CITY OF ALBUQUERQUE

**Re: La Luz del Oeste, Unit 4 Grading and Drainage Plan
Engineer's Stamp dated 07-30-2013 (F-11/D002A)**

Based upon the information provided in your submittal received 07-30-2013, the above referenced plan is approved for Preliminary Plat. However, the following comments should be addressed prior to Grading Permit approval:

SHEET No. 1 of 3

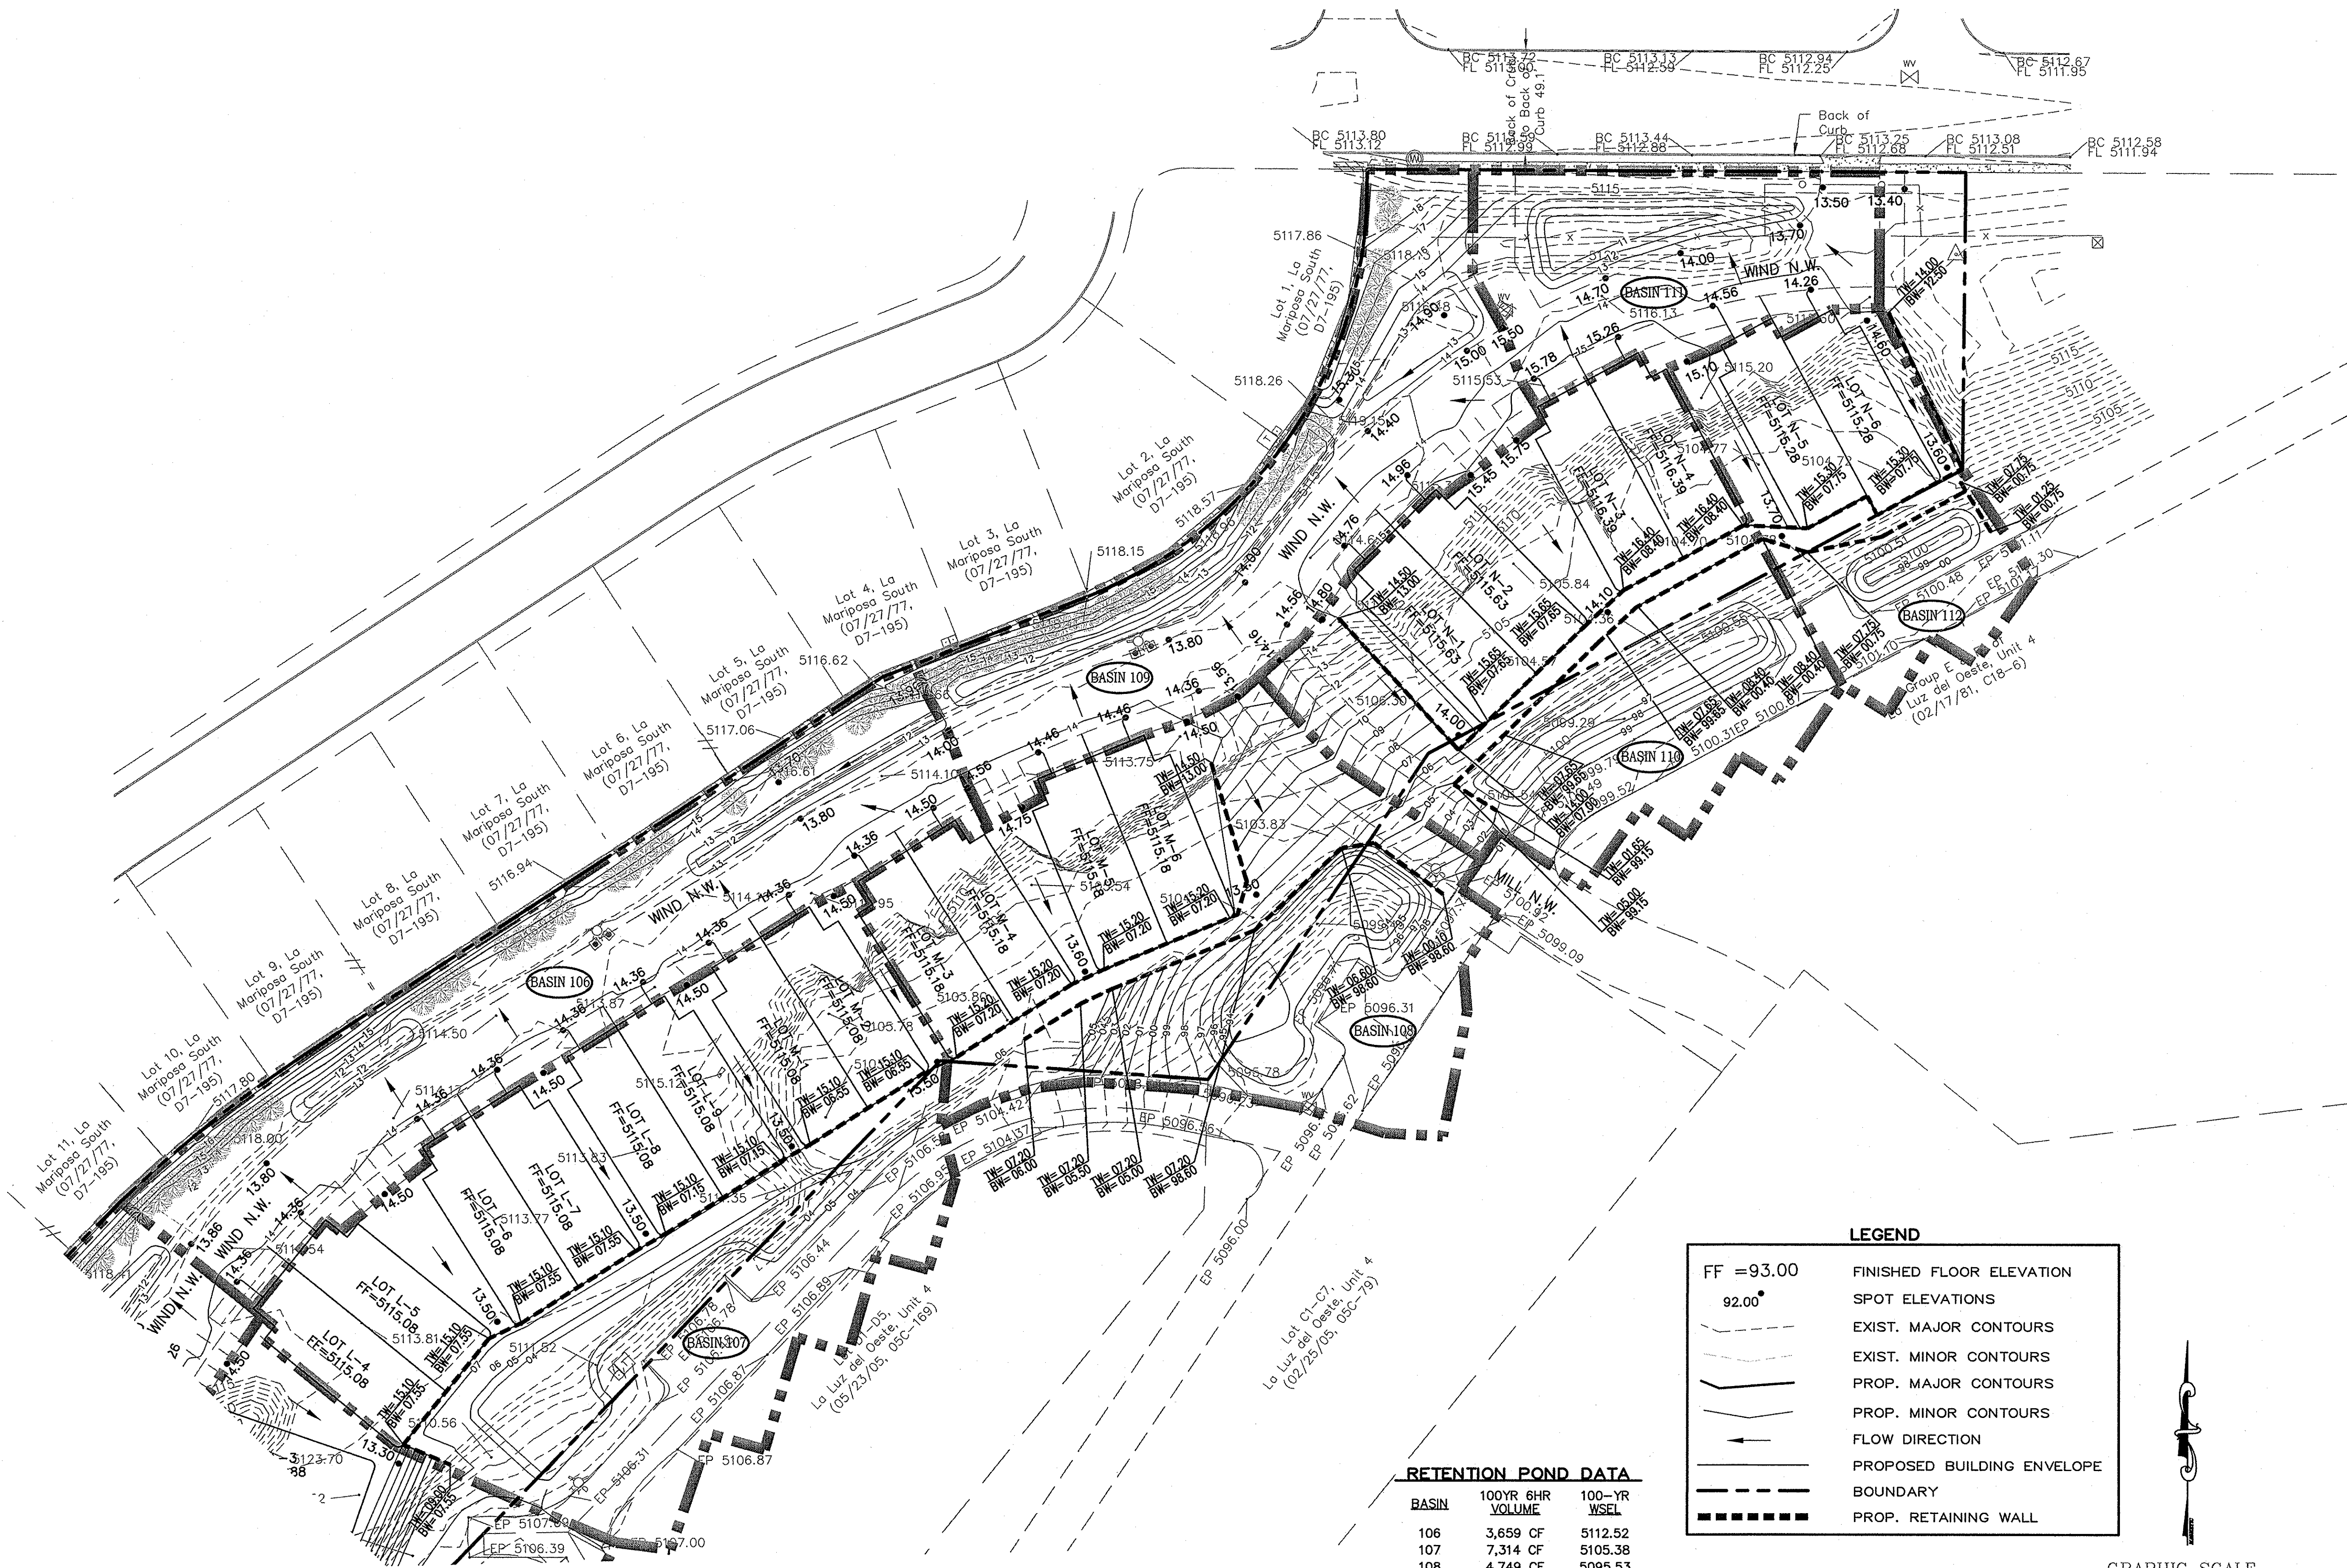
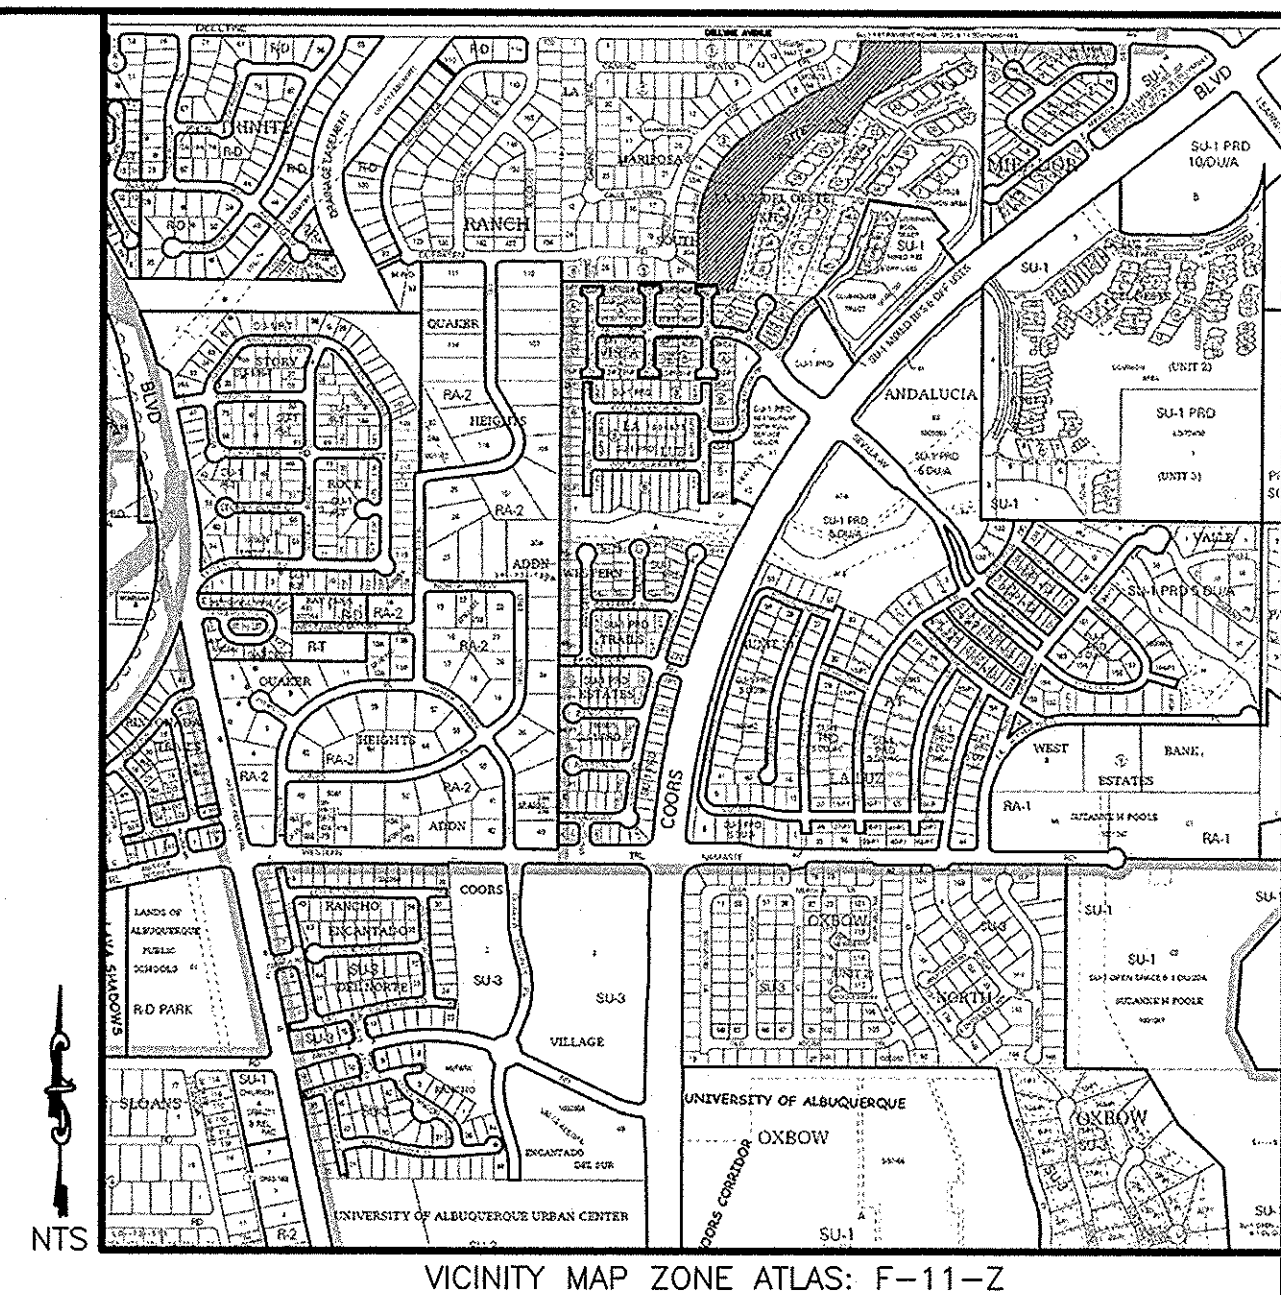
- Show the location of the temporary turnaround area on the plans including the grades.
- Check the grades behind Lots K-2 and K-3. The slopes appear to be steeper than 3:1. Are there any slope protection proposed?
- Check the grades around all the ponds. The proposed topography does not tie to the existing topography.
- Existing topography within Basin 107 close to the ponding area does not appear correct. Check the retaining wall elevation on the west side of the Basin 107.
- How will the runoff within basins 108 and 110 enter the pond along Mill NW.
- Show existing grades along Dellyne Ave. Is there adequate water block at the entrance located within Basin 111 to Dellyne Ave.?
- Where is Basin 113?
